WRITTEN REPRESENTATION

East Pye Solar — Planning Inspectorate Reference EN0110014

Submitted by: Mr. Stuart Shearer & Mrs [REDACTED] Shearer – Interested Parties

Date: 10th September 2026

Drawing file: published-documents / EN0110014-000141-6.2.7.5.5 Environmental Statement Volume 2 Figure 7.5.5 Site 7 Zone of Theoretical Visibility.pdf

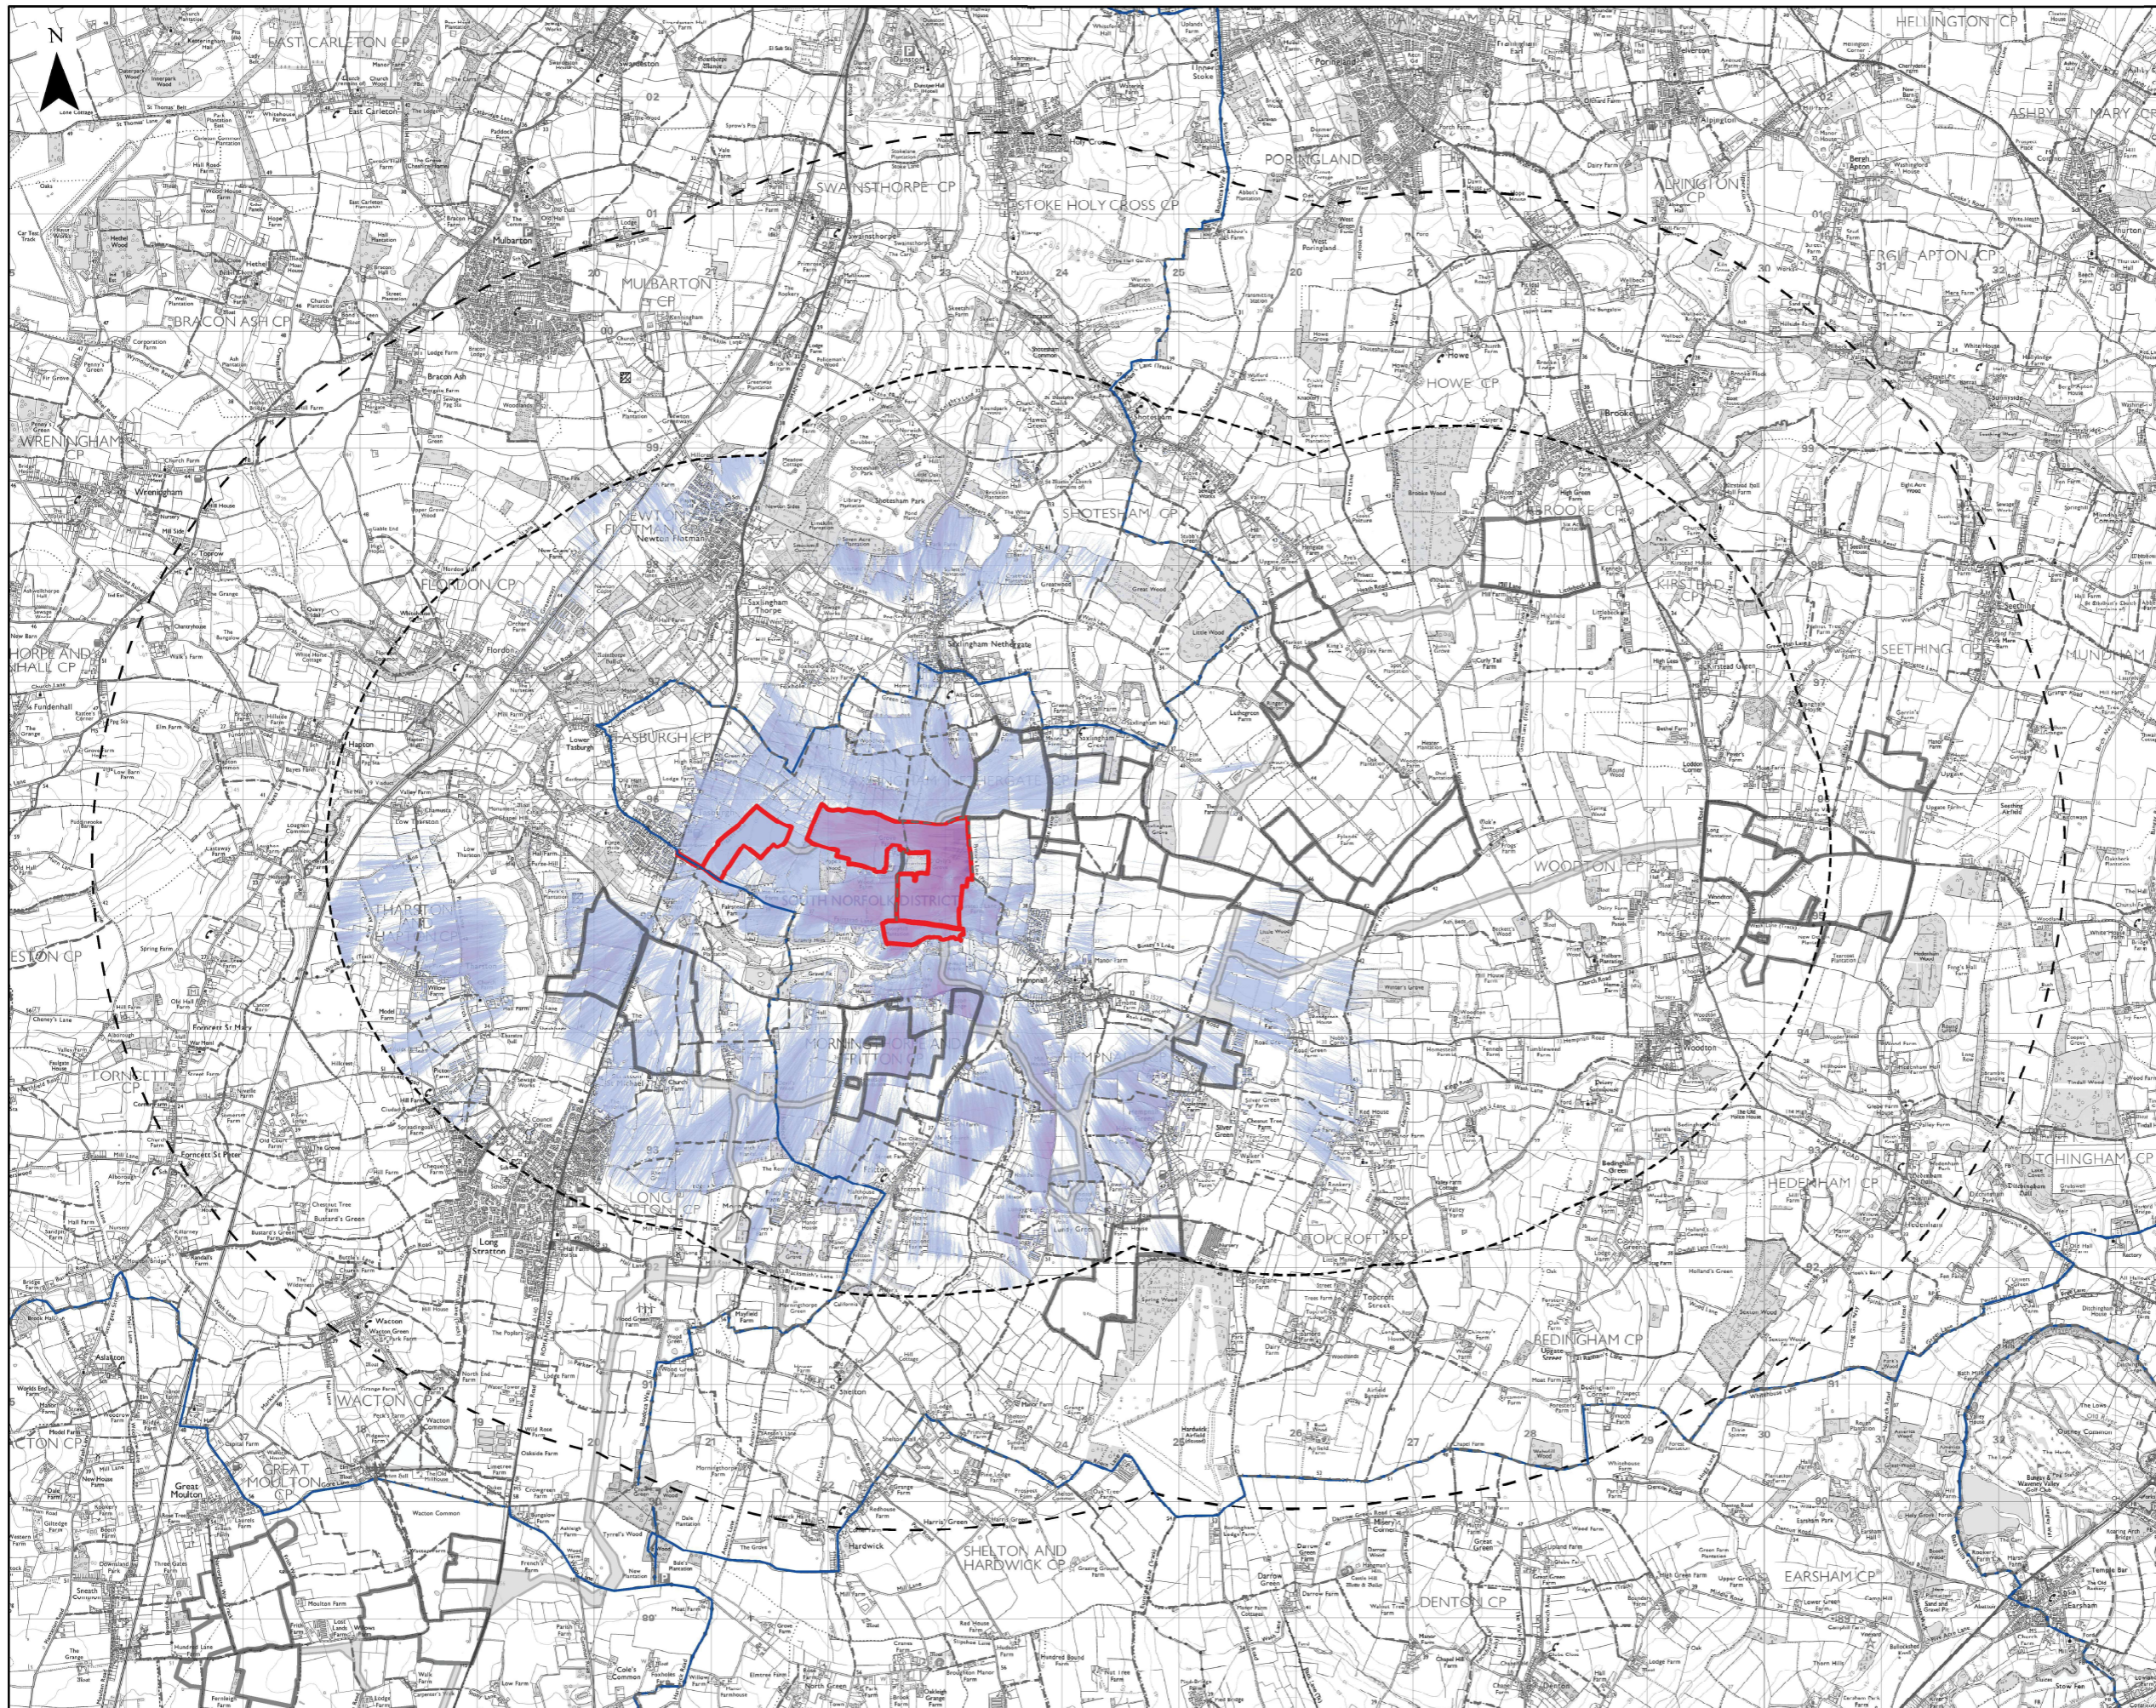
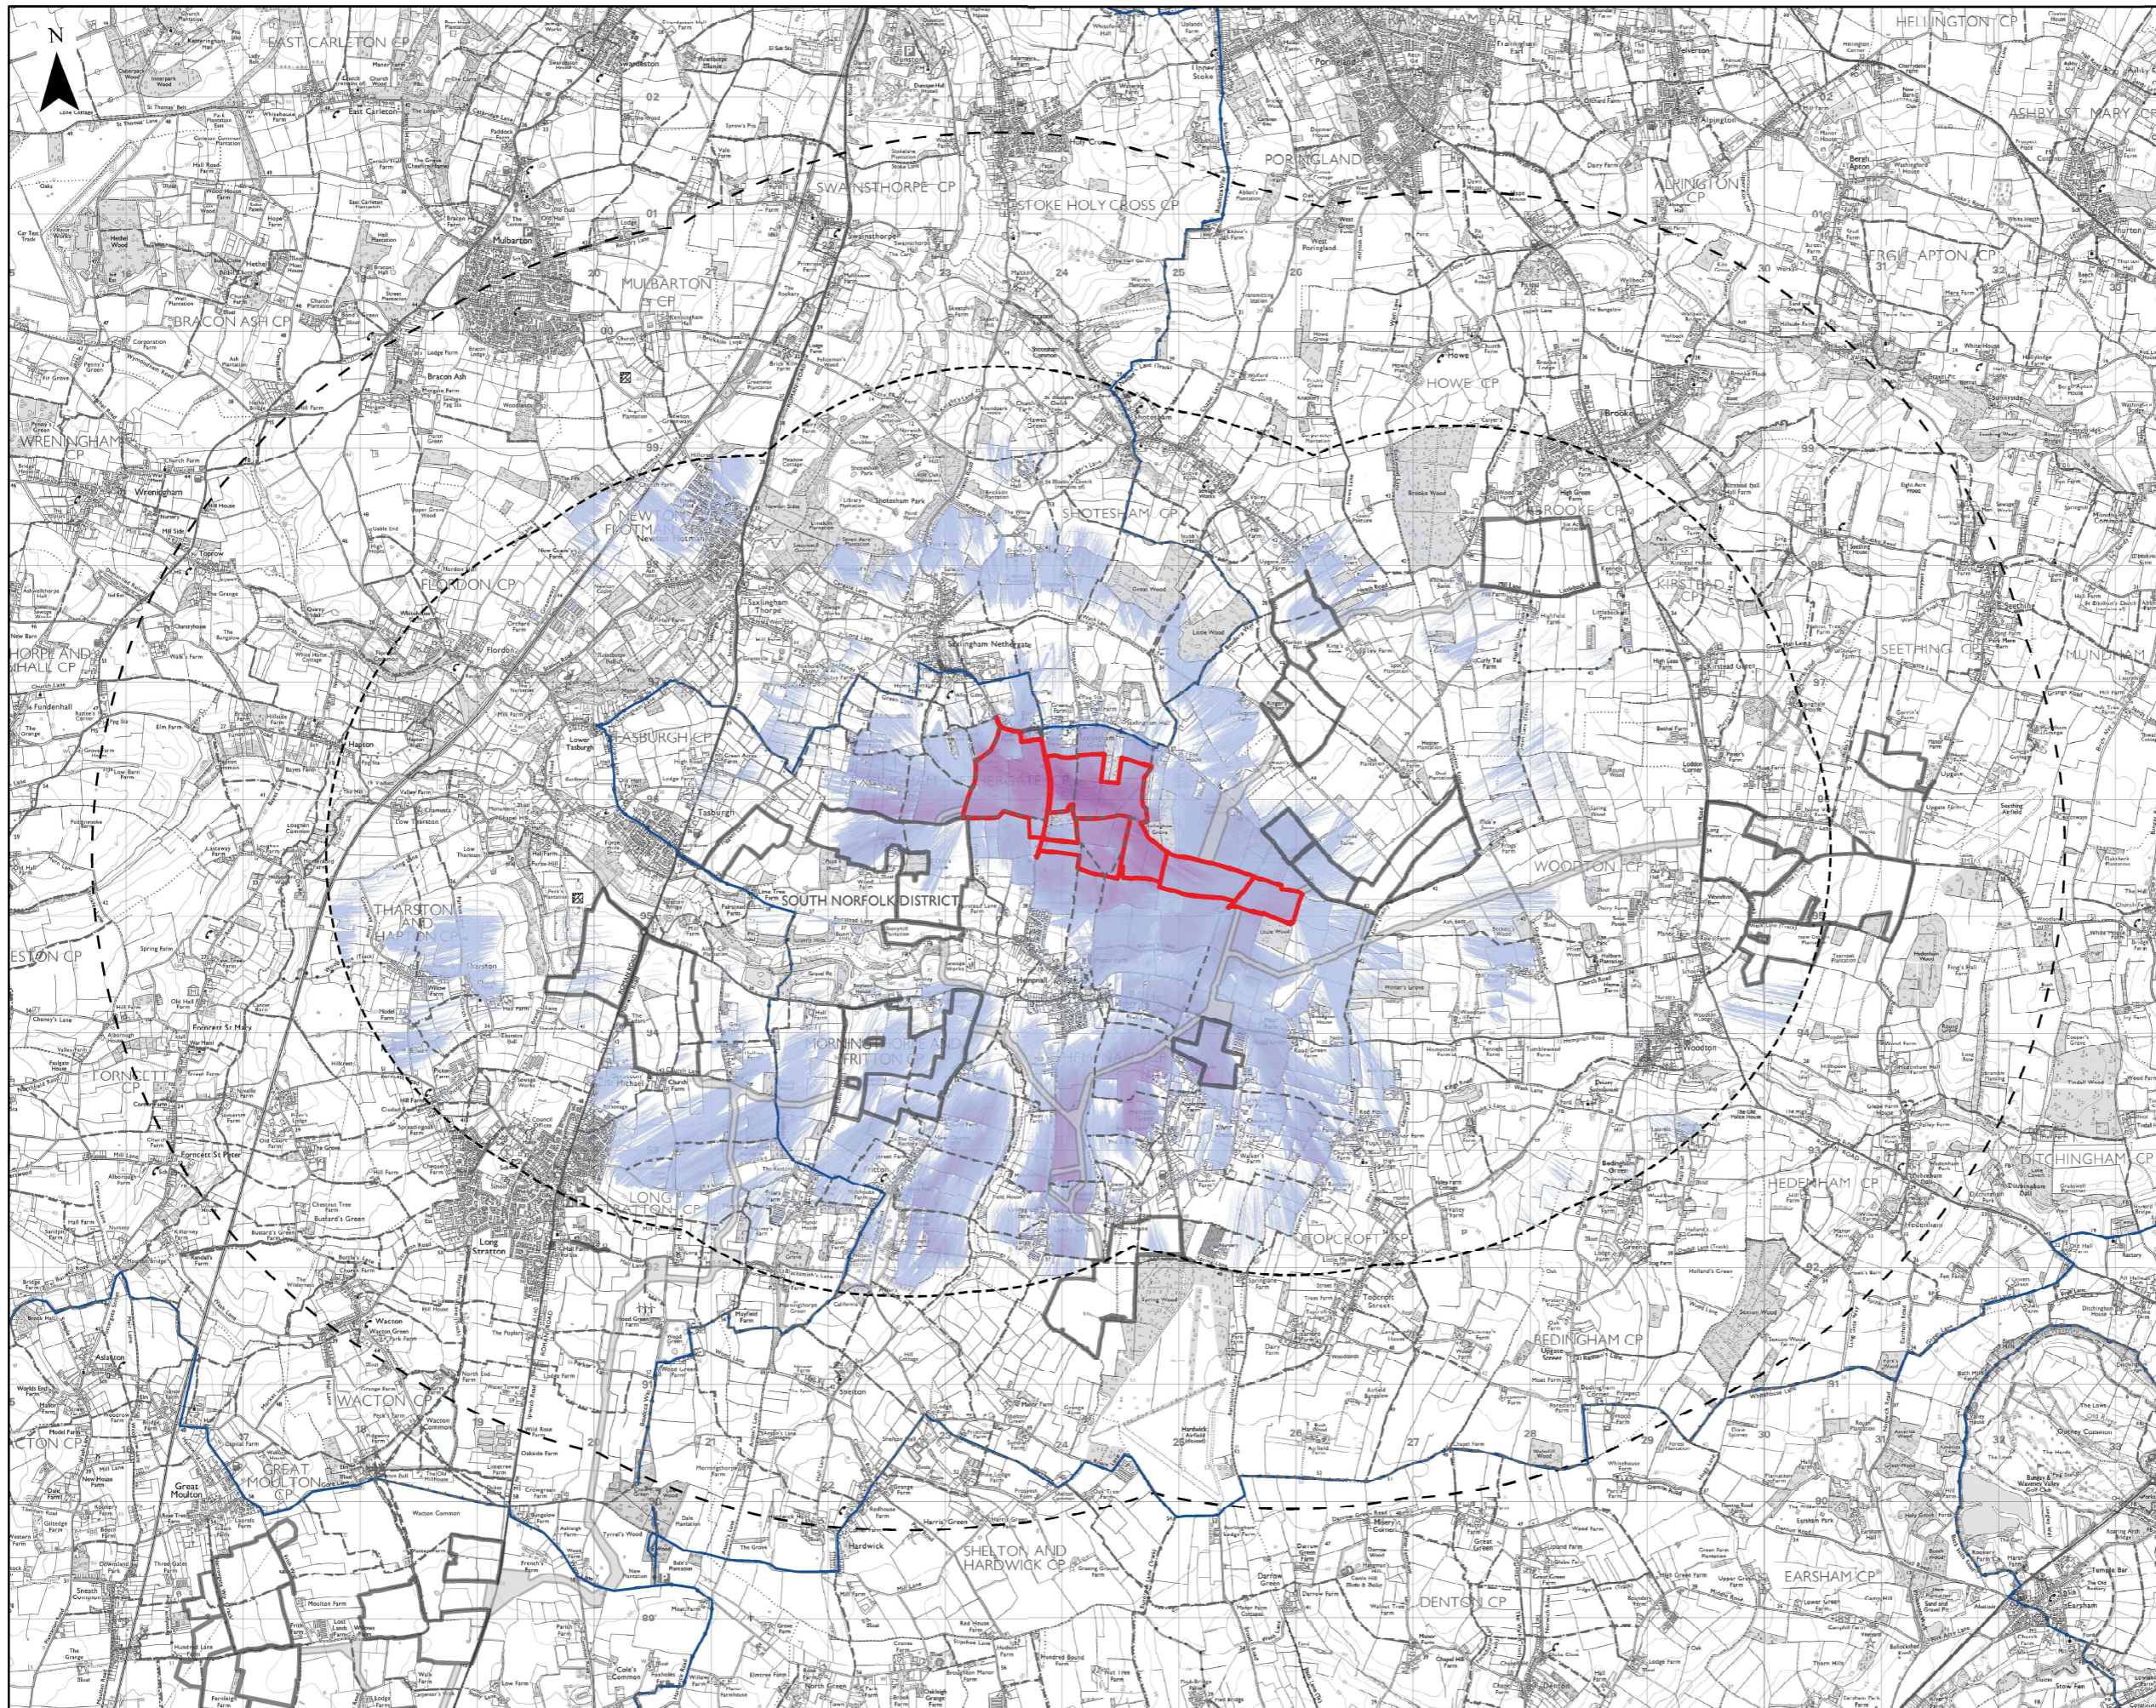
2.12 The Planning Inspectorate's Scoping Opinion (noted in Table 7.1 of ES Chapter 7) specifically directed the Applicant that the ES should assess potential effects on views and visual amenity within the ZTV where significant effects are likely. We request that the Examining Authority requires the Applicant to confirm whether the Property falls within the ZTV for Site 8 (Figure 7.5.4) and Site 7 (Figure 7.5.5) and, if so, to explain why it has not been assessed as a named residential receptor viewpoint.
